PROJECT NAME: VOLLMER ROAD RV AND BOAT STORAGE
OWNER: SCOTT BELLKNAP scott.bellknap@yahoo.com
PROJECT ADDRESS: 8815 VOLLMER ROAD
COLORADO SPRINGS, CO 80908
PROJECT DESCRIPTION: LANDSCAPE PLAN

SHEET TITLE: LANDSCAPE PLAN

FILE NO.: PPR-2245

SHEET TITLE:  
**LANDSCAPE PLAN**

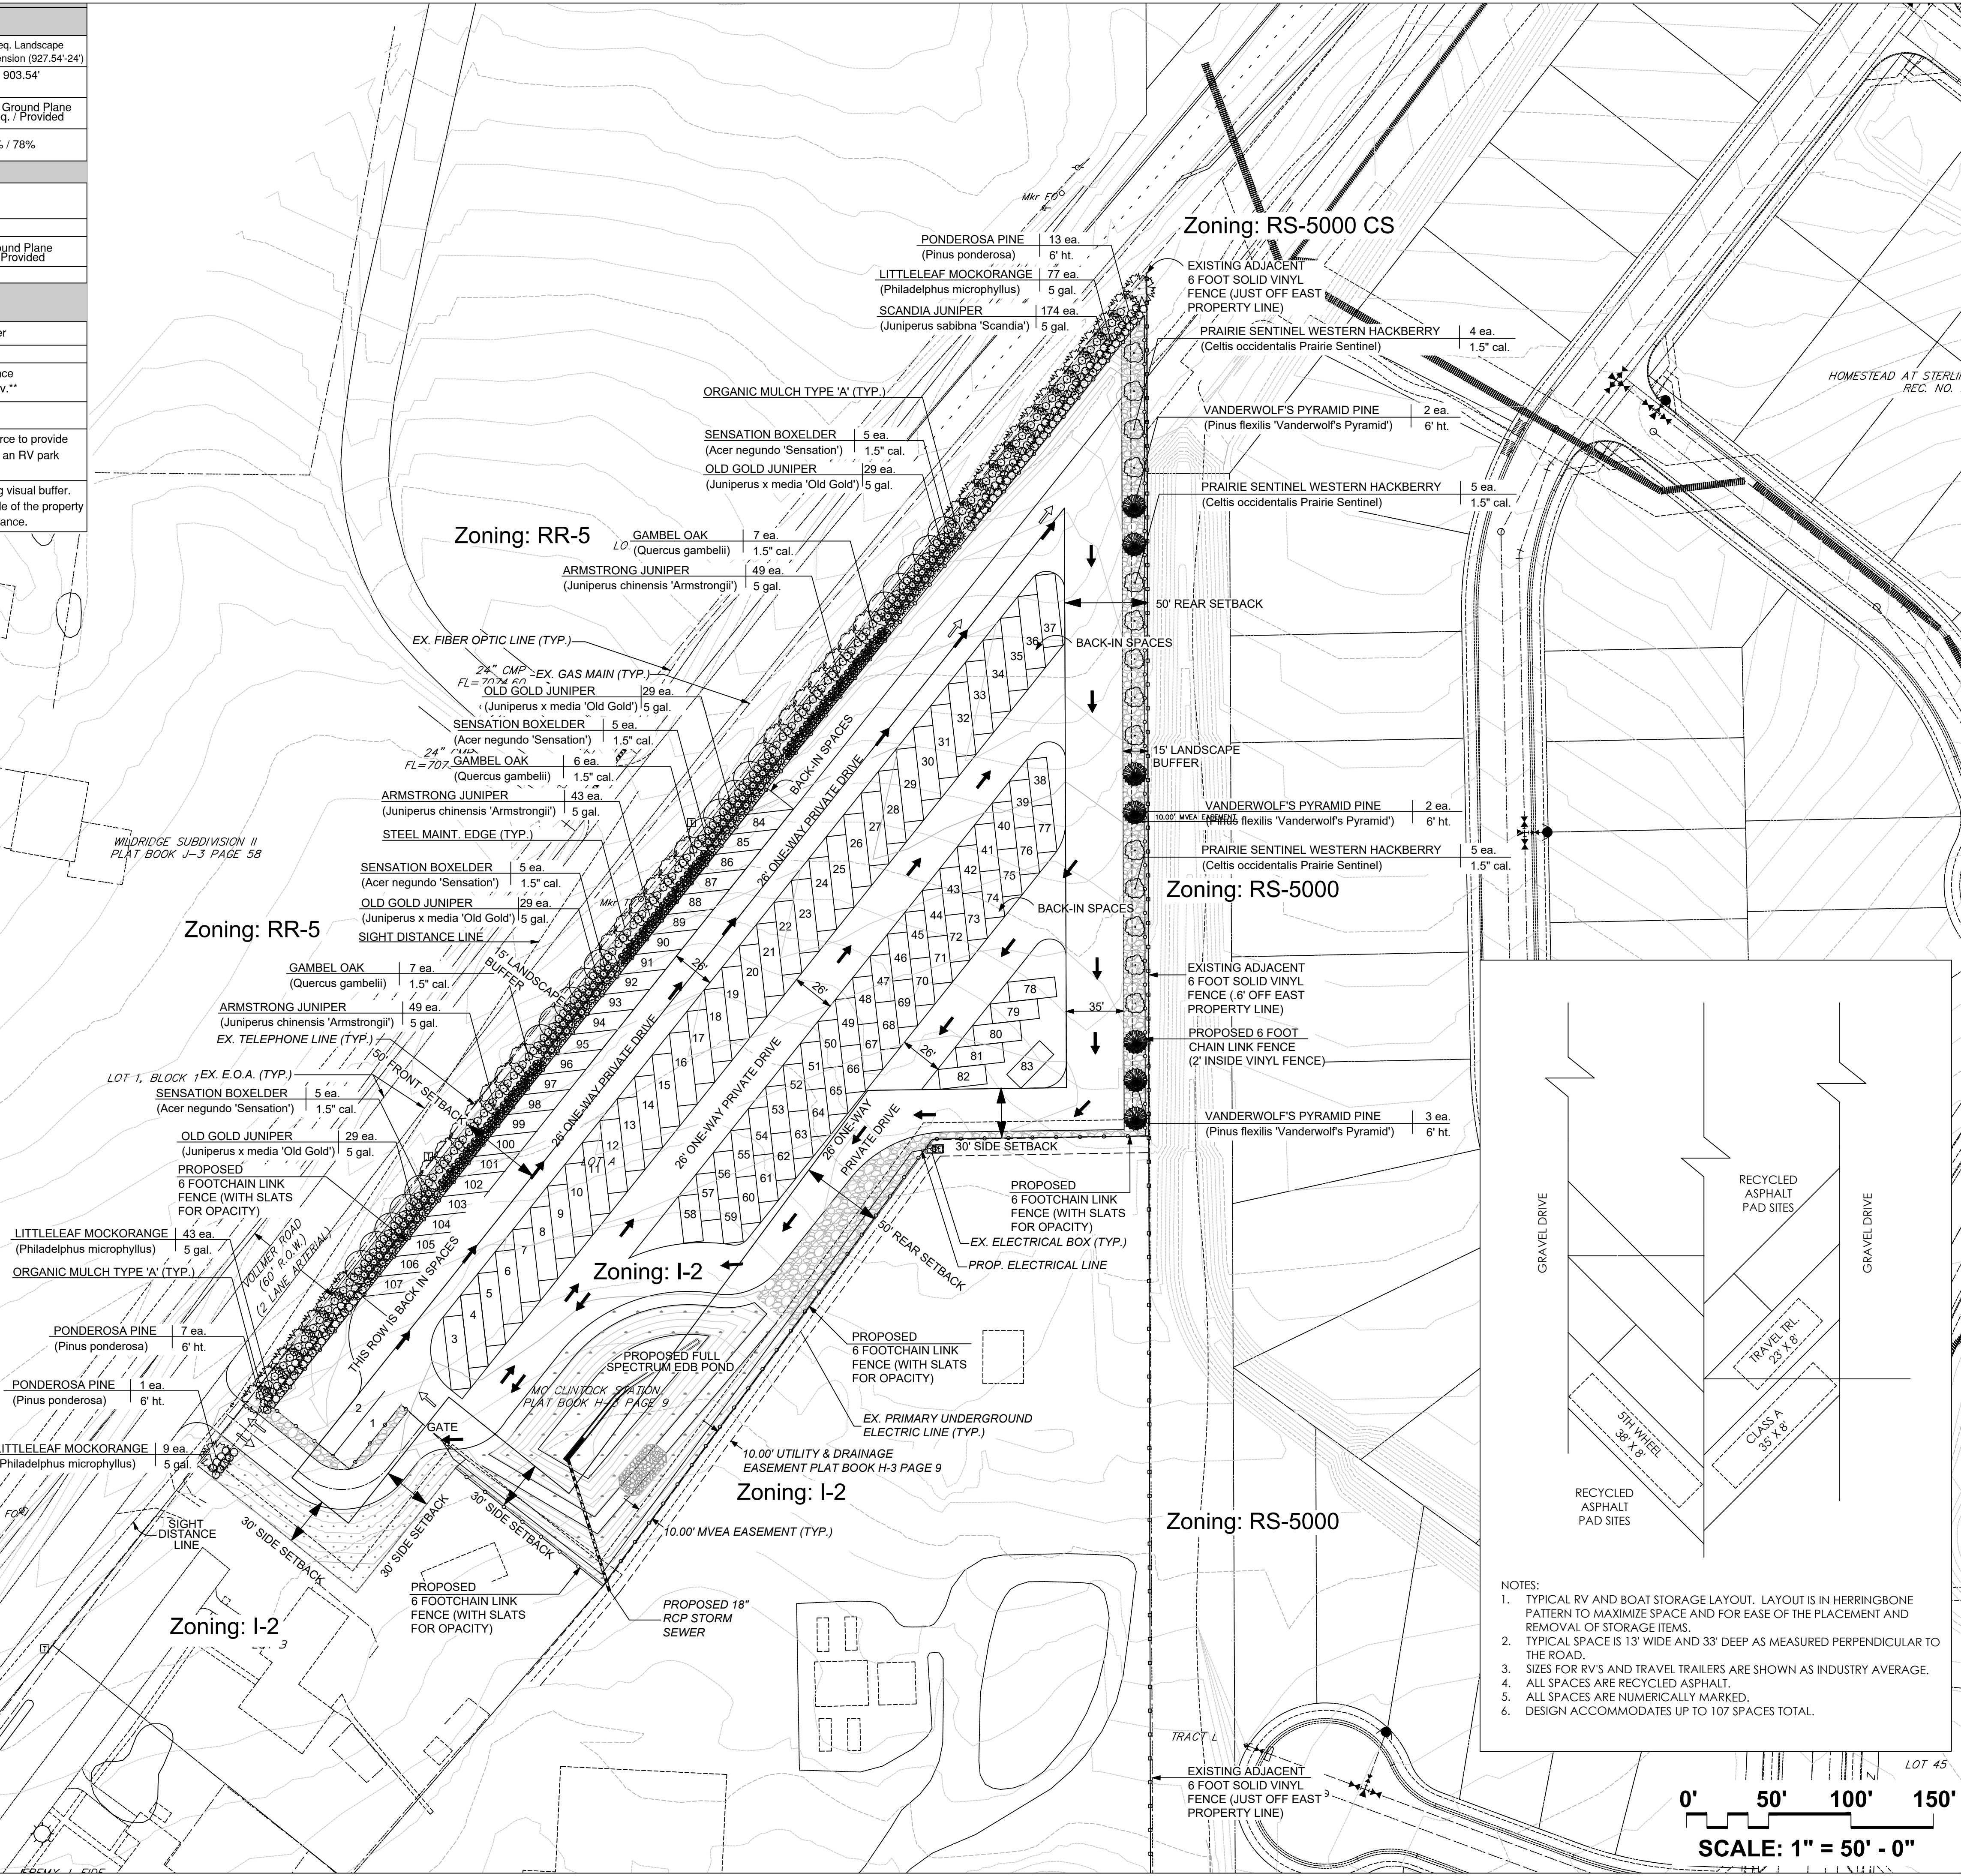
can you show how many grasses and shrubs make up the 75% ground coverage

The LDC states that the director cannot eliminate the requirement for landscaping or to diminish the total landscaped area required by the code

You are providing plantings for the buffers if you are using drought tolerant plantings there i would suggest you can also plant internally

Can you add trees or shrubs here?

Can you add native grasses here but not in the spillway?

NOTE : ALL NEWLY INSTALLED LANDSCAPE MATERIAL WILL BE HAND WATERED UNTIL ITS ESTABLISHMENT. NO WATER EXISTS ON-SITE.
